Road Safety Audit Response Report

Lidgett Road Junction,

Report: 7795-HJCE-00-XX-DP-0002

Date: 26.08.25

7995-HJCE-00-XX-DR-C-4300 P06

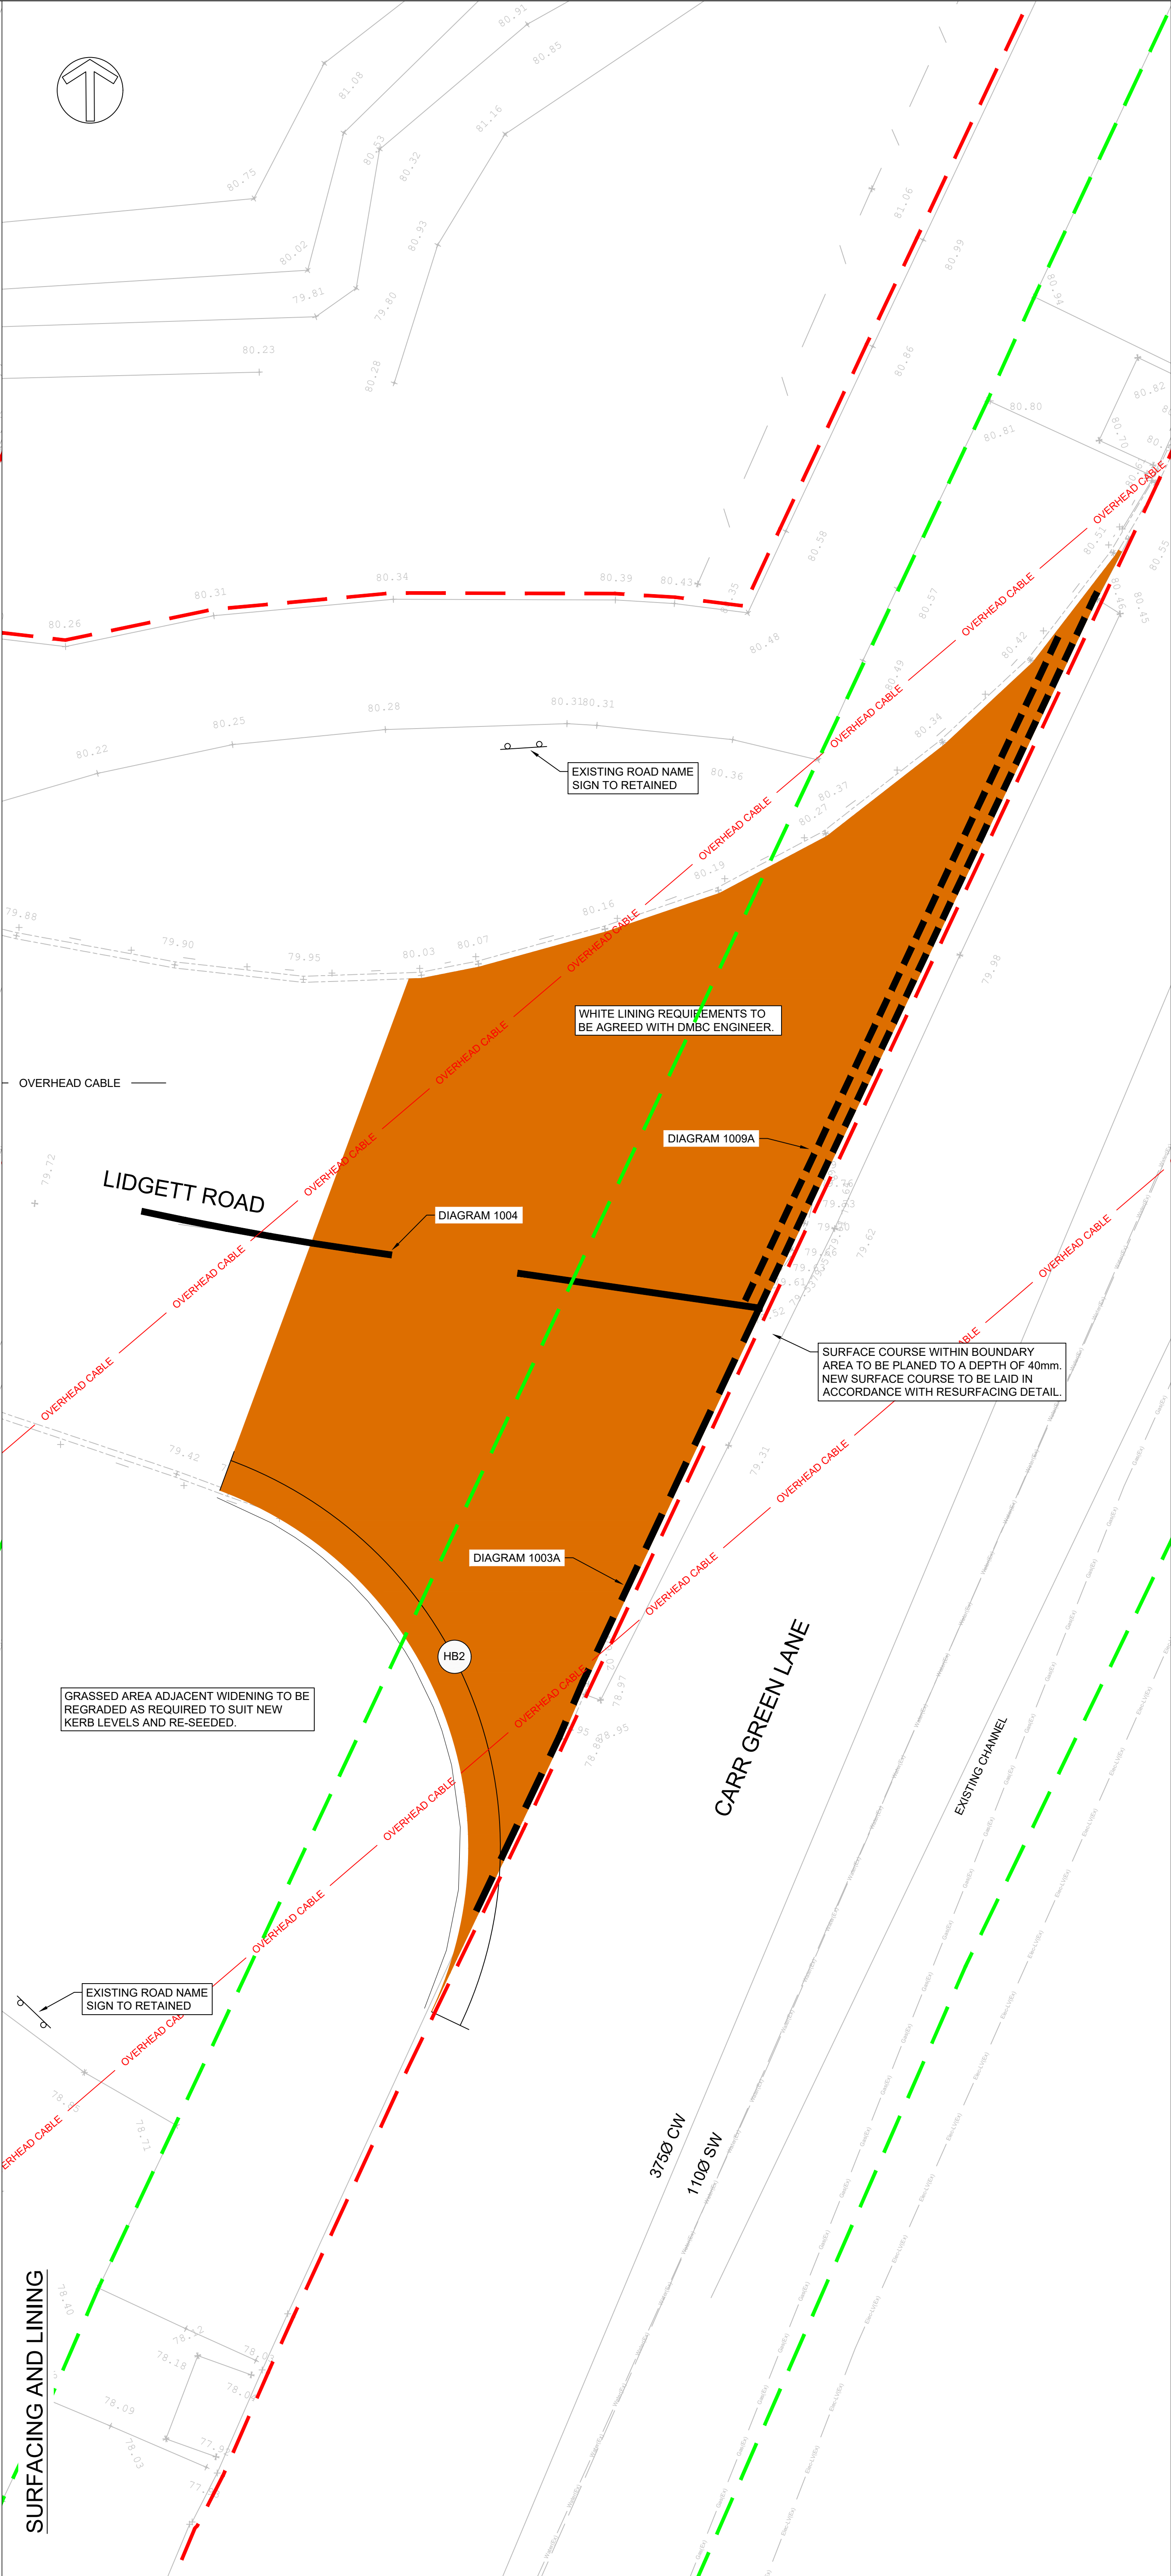
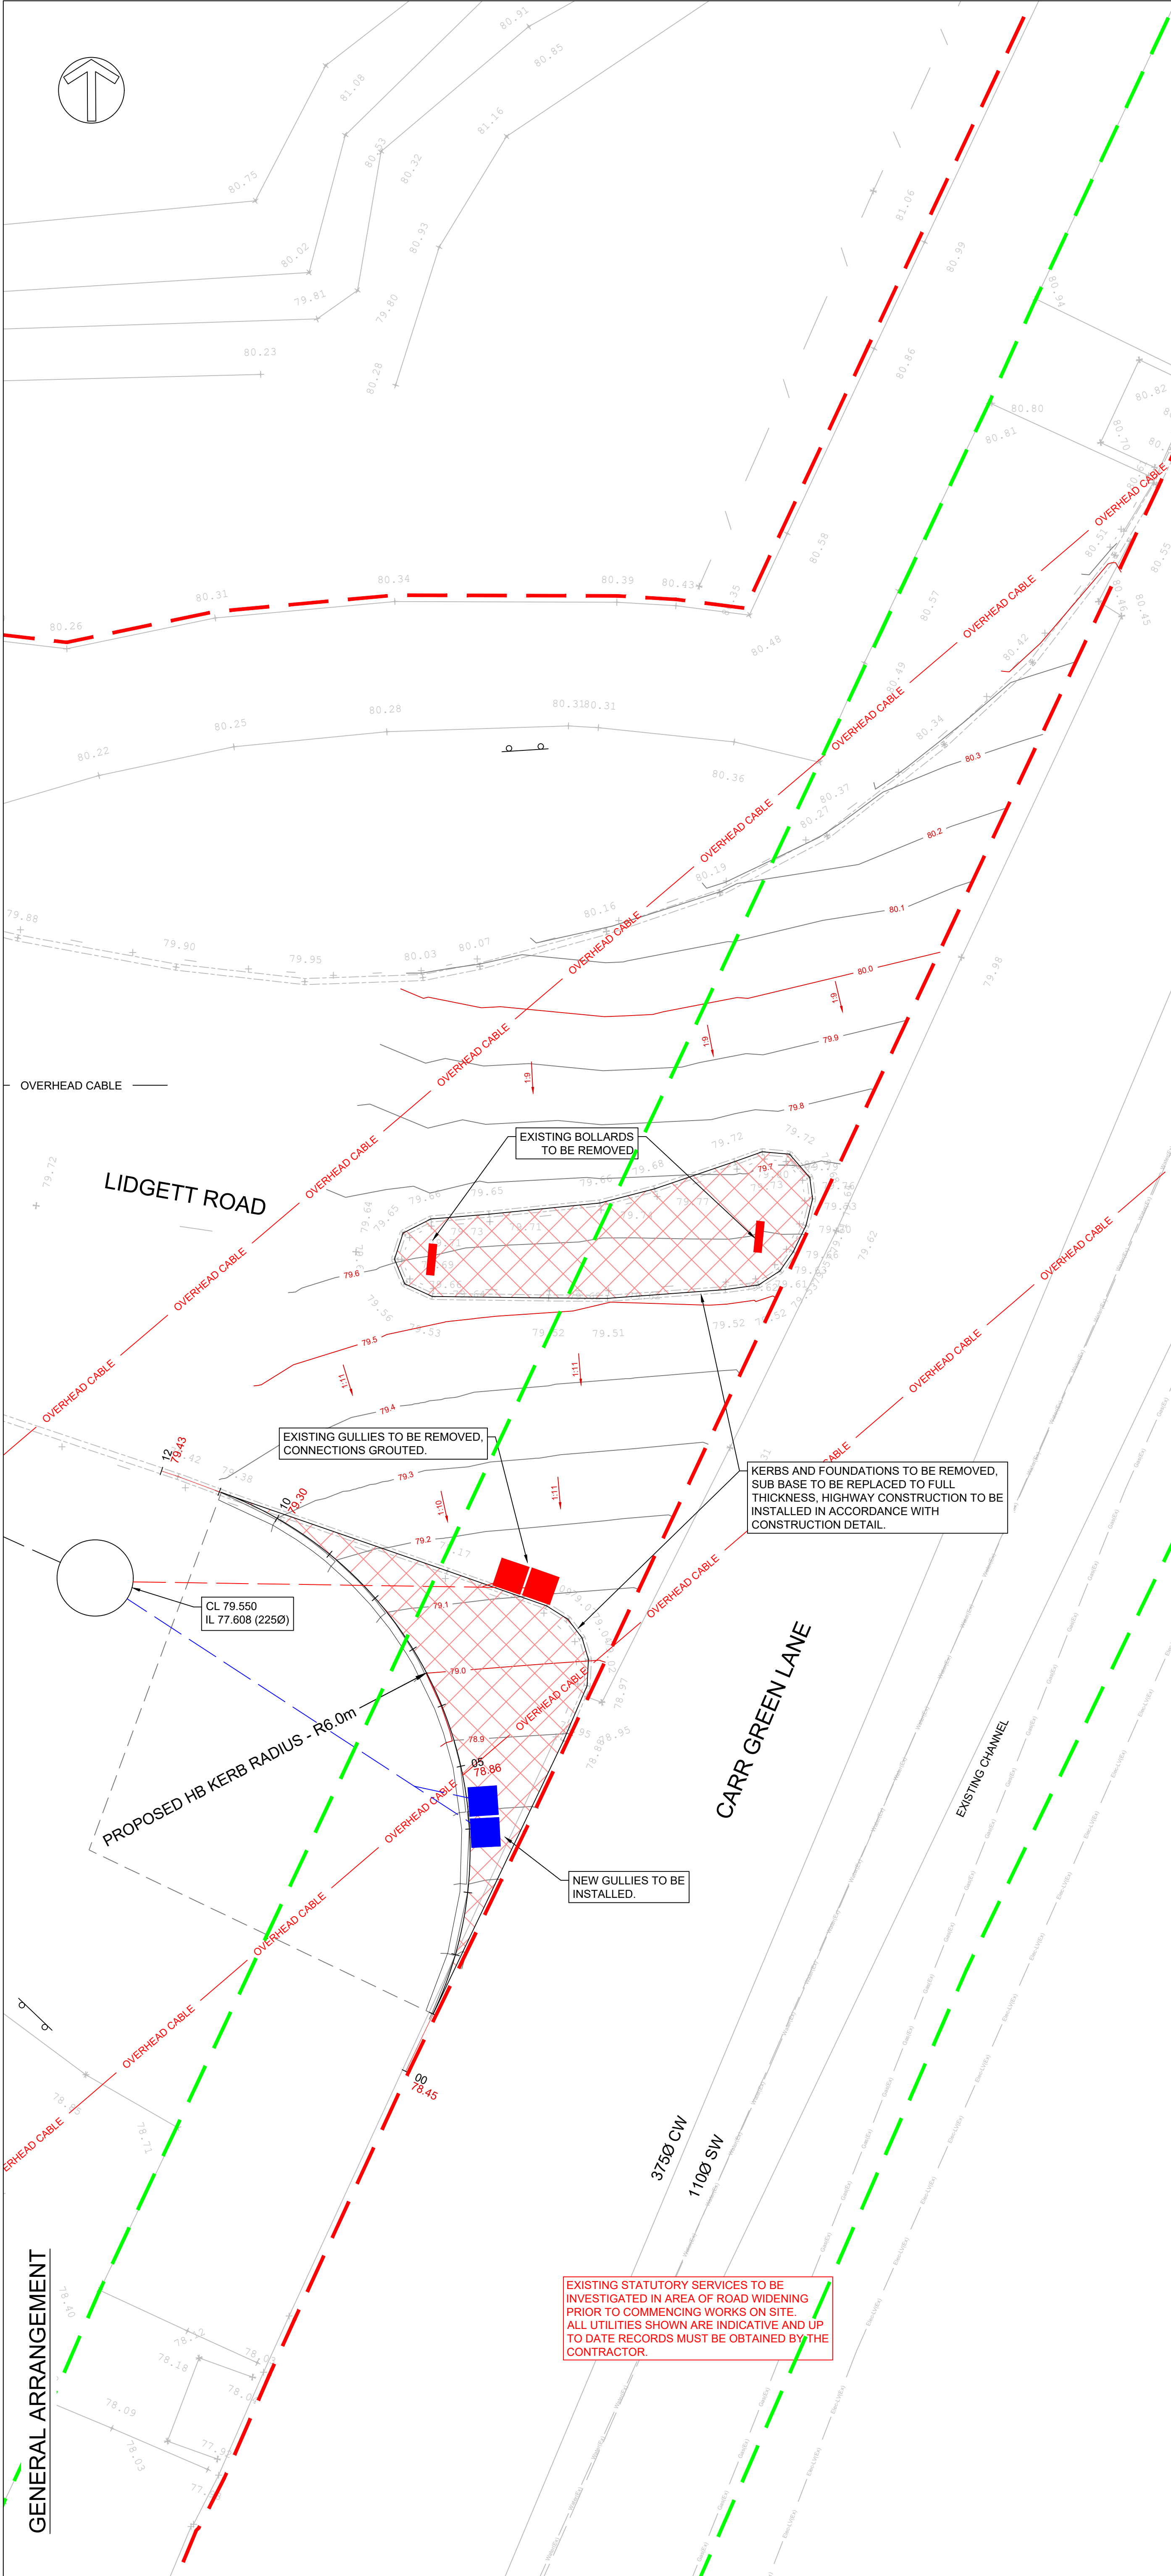
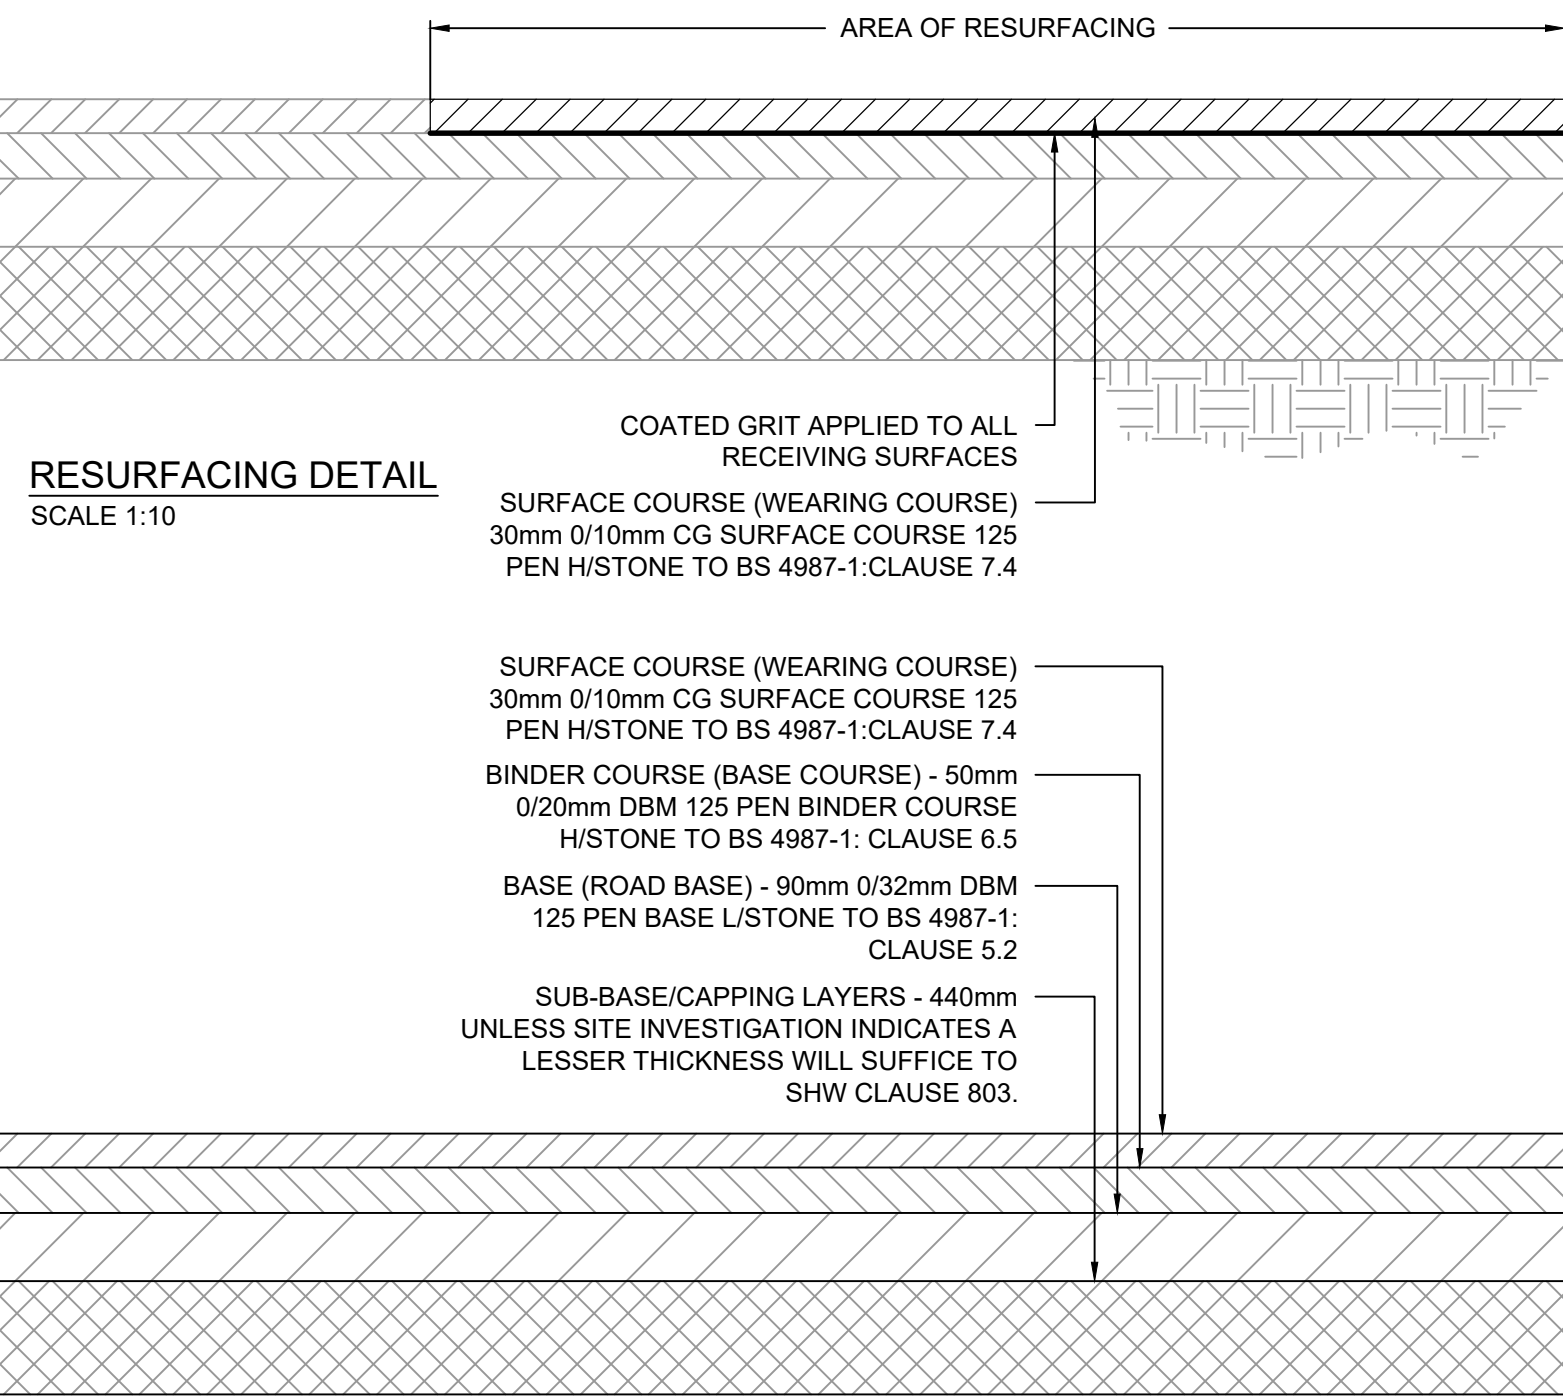
Location	Summary	RSA Problem	RSA Recommendation	Designer Response	Overseeing Organisation Comments	Agreed RSA Action
B1-01	Carr Green Lane – At the three pedestrian crossings.	Skidding Resistance – Insufficient skidding resistance may increase the risk of collisions involving skidding.	Three new pedestrian crossing points are to be provided. The provision of these will change the site category in terms of the definitions within DMRB CD 236. Although some resurfacing is indicated on the drawings, this extends only between the middle and northern crossing points, does not include one approach for each and does not encompass the southern crossing point. The existing carriageway surface that is not proposed to be resurfaced has a number of utility reinstatements as well as some surface cracking in areas and is unlikely to offer a sufficient level of skidding resistance. Insufficient skidding resistance, especially in higher risk areas such as at pedestrian crossings, may increase the risk that collisions involving skidding occur.	It is recommended that the carriageways on and through all three proposed crossing points are provided with a skidding resistance commensurate to DMRB CD 236, Table 3.3a or Table 3.3b based on the relevant site categories and traffic levels.	Agreed. The proposed works under Section 38 and Section 278, together with the remedial works agreed with the council, encompass resurfacing of the highway between the proposed pedestrian crossings on Carr Green Lane, along with a minimum of 15m approaching the crossings. It is the view of both the designer and the client that the highways outside the Agreement boundaries fall under the council's responsibility and that any required maintenance of the adopted highways should therefore be undertaken by the council.	For clarity, 2 of the pedestrian crossings are existing and are simply being relocated, with only 1no additional crossing being introduced. Based on a review of CD 236 this would therefore not change the site category from what it was previously (assuming the audit team are referring to Cat Q or K). As confirmed by the designer, the 2no pedestrian crossings immediately north/south of the junction will incorporate new full width carriageway resurfacing. However, the current specification of such surfacing does not state if it conforms to table 3.3a/b – i.e. PSV of 68+ for an IL of 0.45/0.5 for site category Q/K respectively. With regards to the most southern crossing, this crossing point – and subsequently the area of carriageway facilitating the use of such crossing – forms part of the S278 highway improvement works. If the RSA has therefore flagged the condition of the carriageway to be unsuitable, we would expect a suitable solution to be provided to ensure the carriageway surfacing is safe for the installation of the new highway infrastructure. We would be open to considering a localised, full width	Carriageway to be resurfaced full width to account for the introduction of the pedestrian crossing point, as demonstrated on the S278 Agreement Layout Rev P05

surfacing patch for the area of the crossing point. We would also expect the designer to confirm the PSV for any surfacing being used and its suitability in accordance with CD236 and the comments in the RSA	
--	--	--	--	--	--	--	--
